Application for approval of matters reserved by condition imposed under AW/211/14/PL relating to conditions 3, 6, 11 & 12 relating to window detailing, watercourse access & maintenance, Servicing Management Plan & pedestrian improvements.

The Ship Inn Aldwick Street Aldwick

Thank you for your internet representation made on 10th March 2015 which has been recorded as '**an objection**' with the comments as follows:

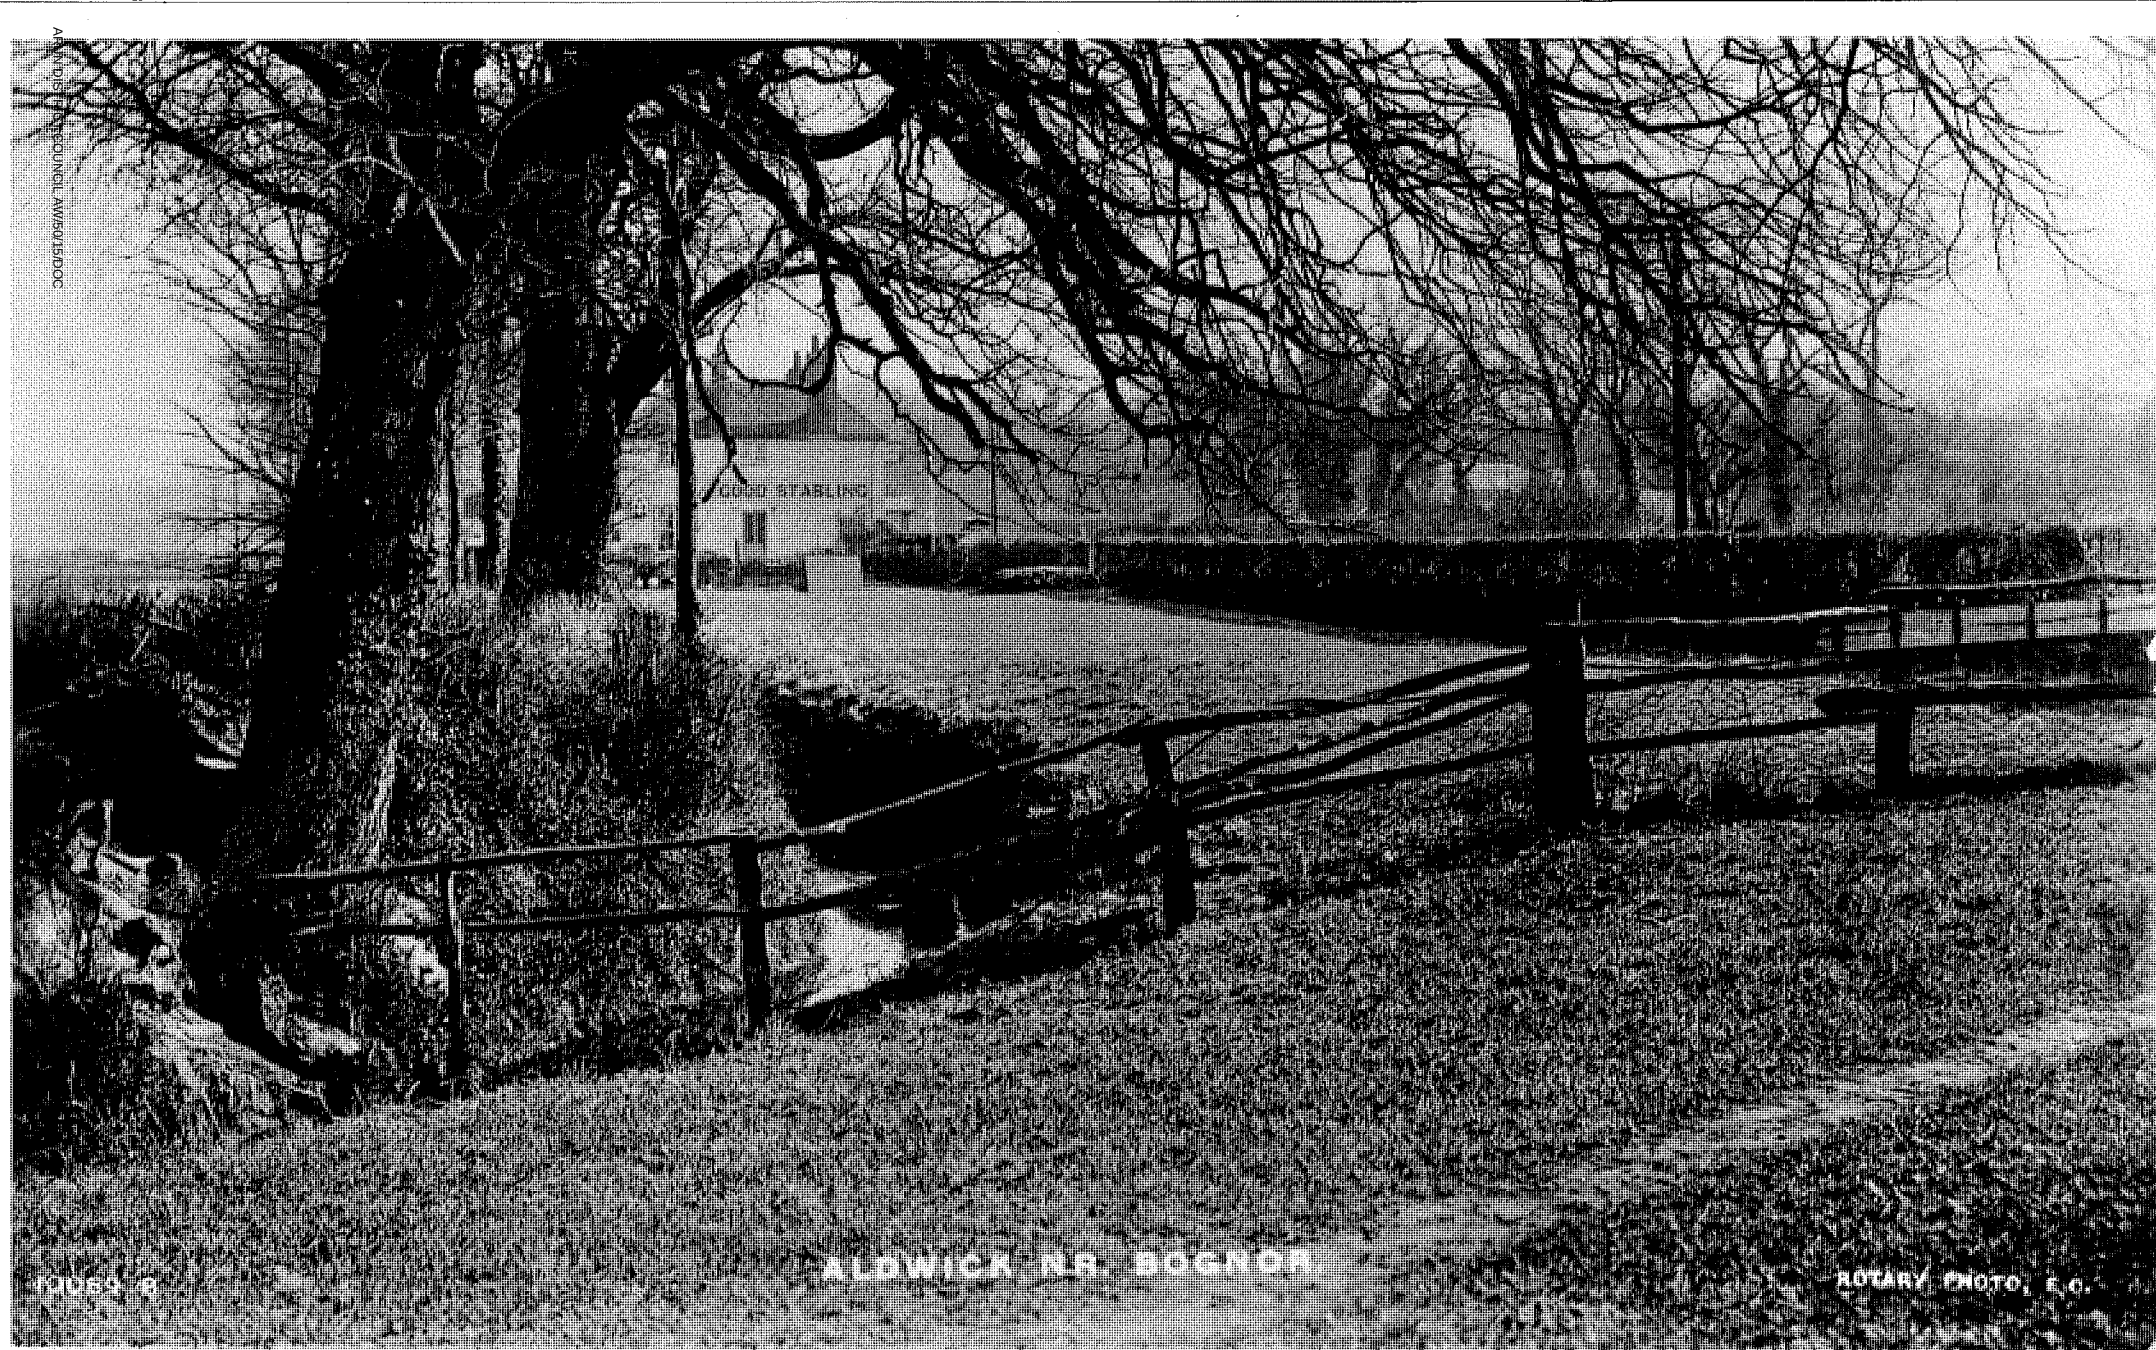
3 They have failed to install pictures of old Aldwick in the windows (as was similarly done by Bon Marche in Bognor some years ago).

DRAWING TITLE
SWEPT PATH

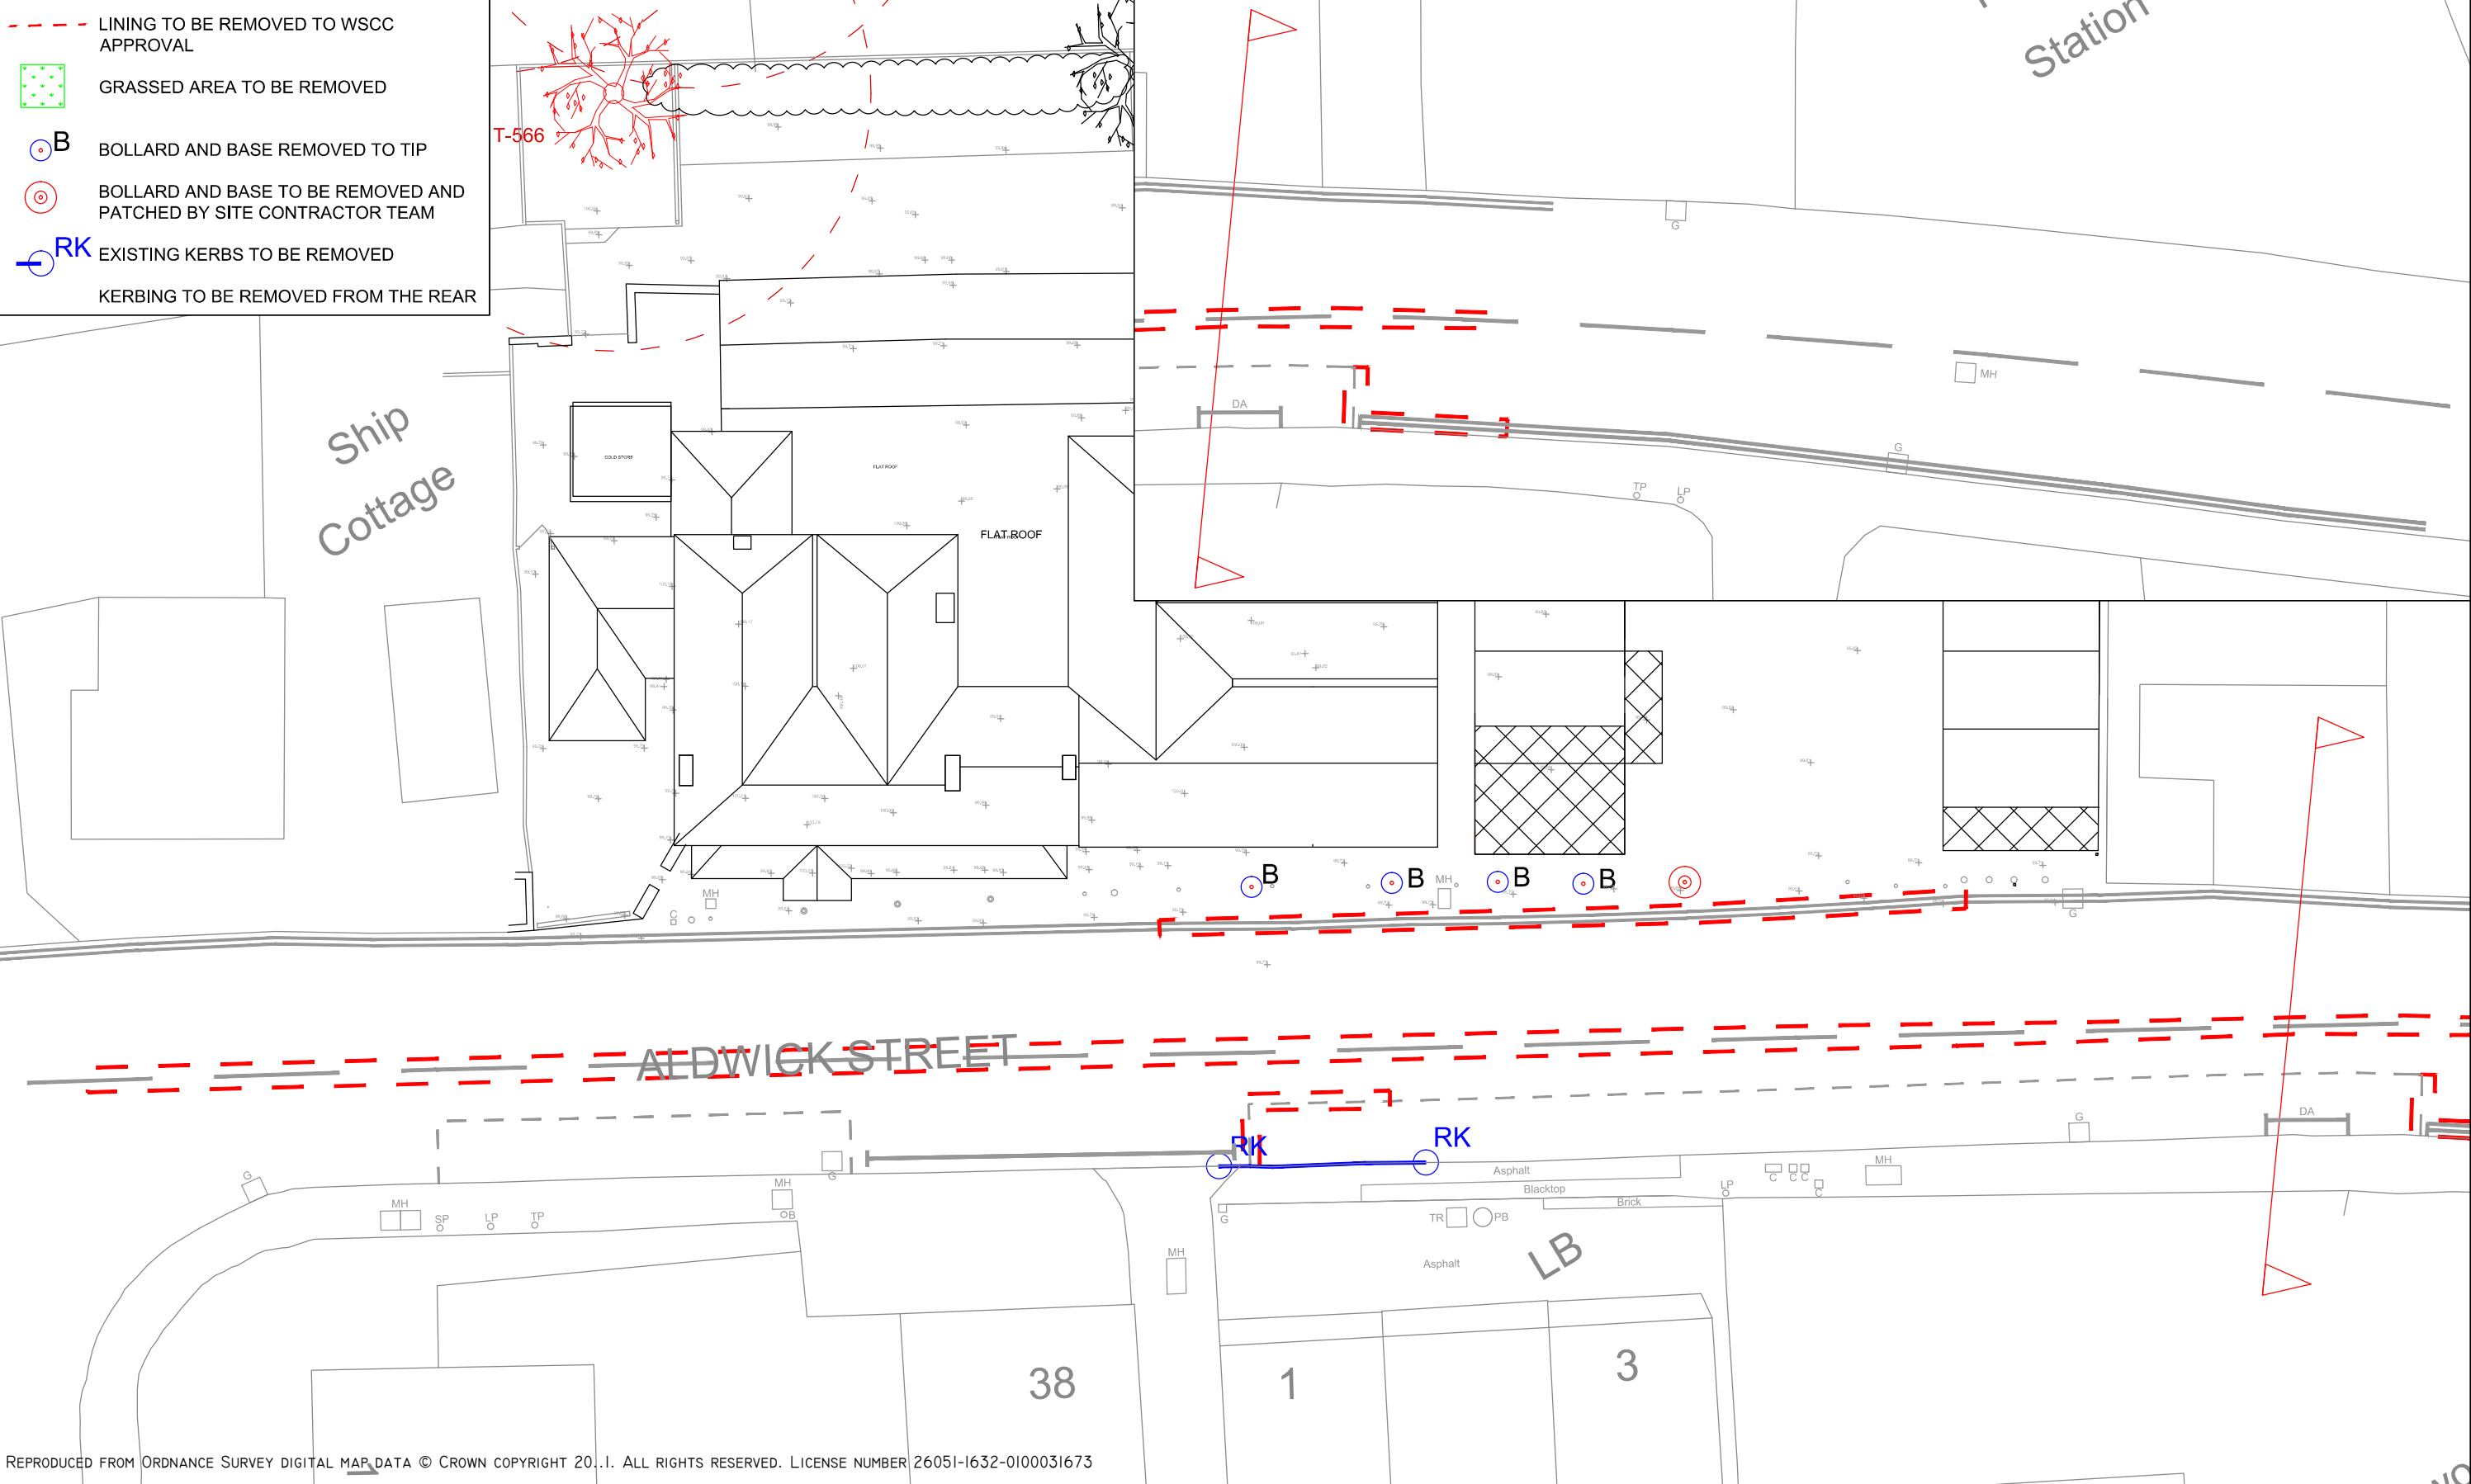
2 There are inadequate arrangements for moving large lorries into and out of the car park. This also affects the safety of pedestrians and motorists alike.

UNCONTROLLED DROPPED CROSSING:

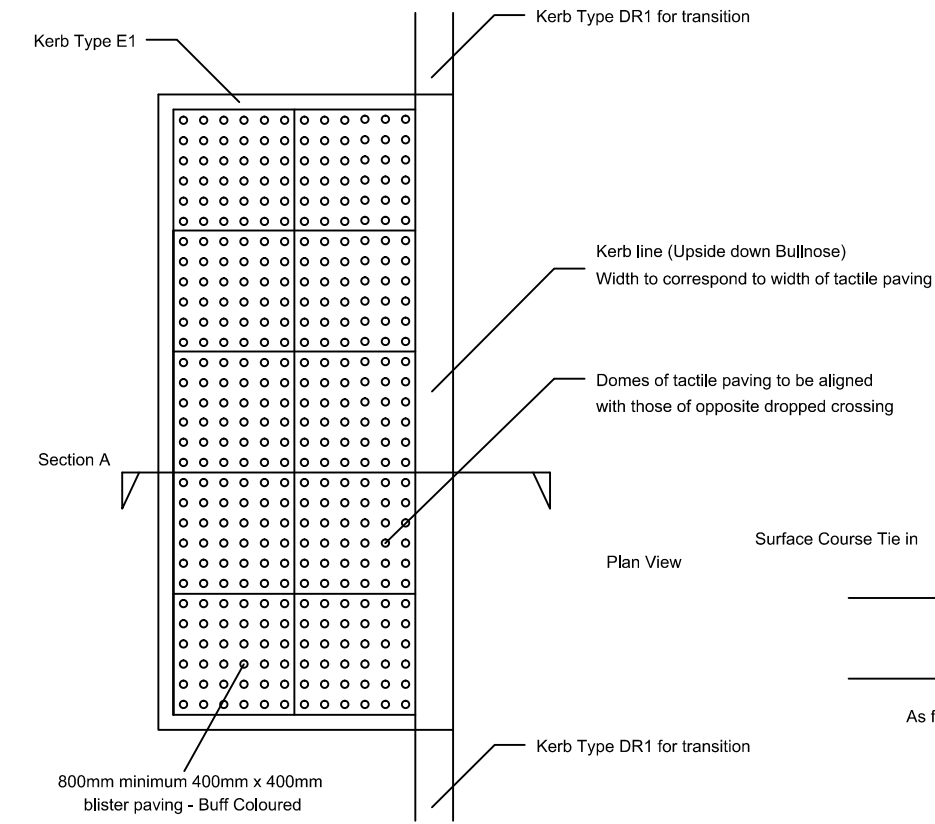
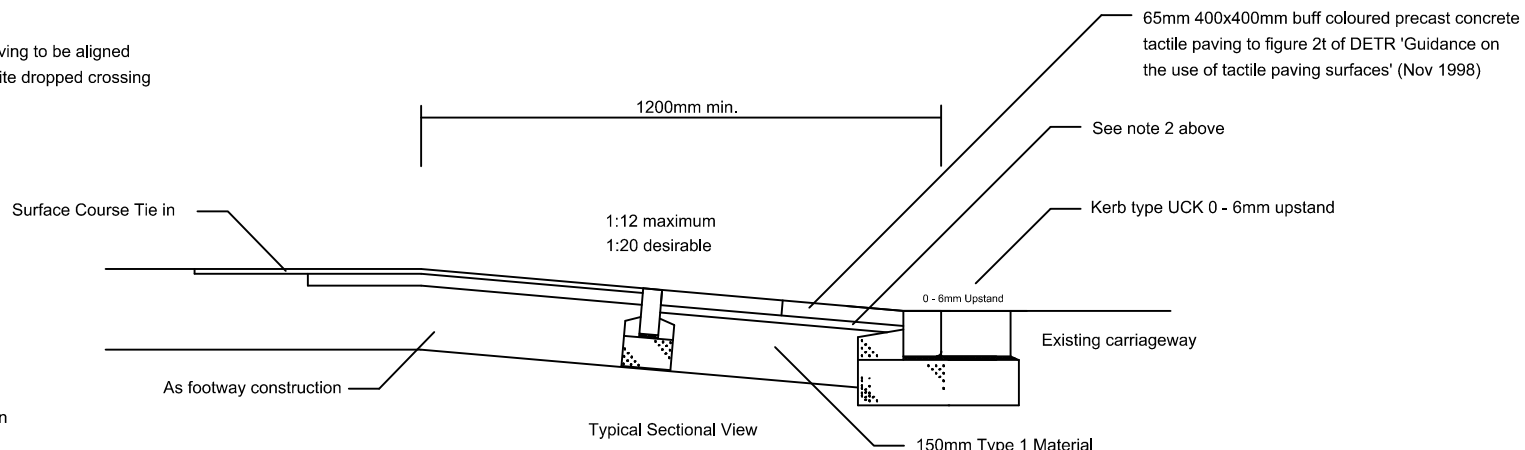
1 The uncontrolled crossing has not been installed with a risk to the safety of pedestrians.
